COMMENTS

LOCATION 39 Forest Ave

**PLAN VIEW - NEW & EXIST.
RAMP & STEPS**

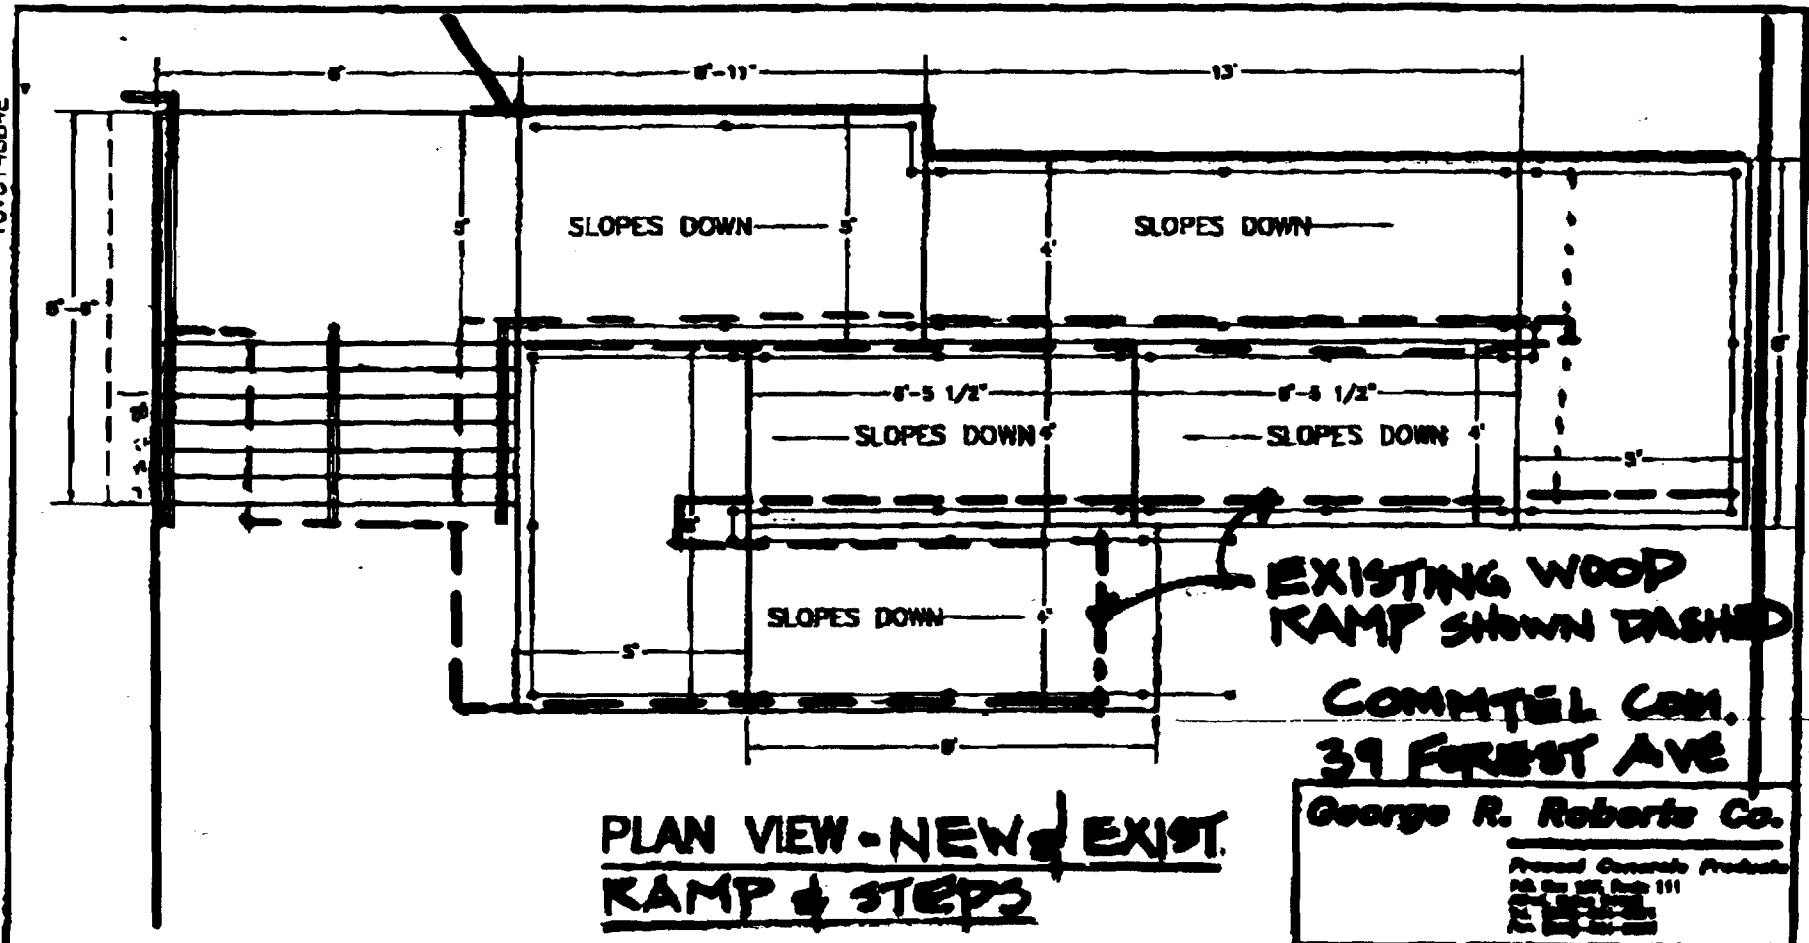
3/12/01 - plans show a new exterior ramp - called Benchmark. left a message that a site plan review or site plan exemption would be required.

3/14/01 Architect Cynthia McMullin called - There is an existing wooden ramp there and they will be changing it to concrete - No change in size per her - will fax a revised plan -

4/19/01 Final - punch - for phase one - Forest ^{Ave} Street side w/SH - need Emerg. Lighting at rear egress in main Room, stairs at Ramp only 10 1/2" tread. JB

7/18/01 Final for phase 2. Need spec on enclosed glass Room safety glazing. HC Ramp Guards only 34" in height. See enclosed Fax sent to inform of BOCA & Life safety Code. Can issue a Temp C.O. JB LTMAC Needs Alum Report

9/18/01 HC Ramp Guardrail ok JB
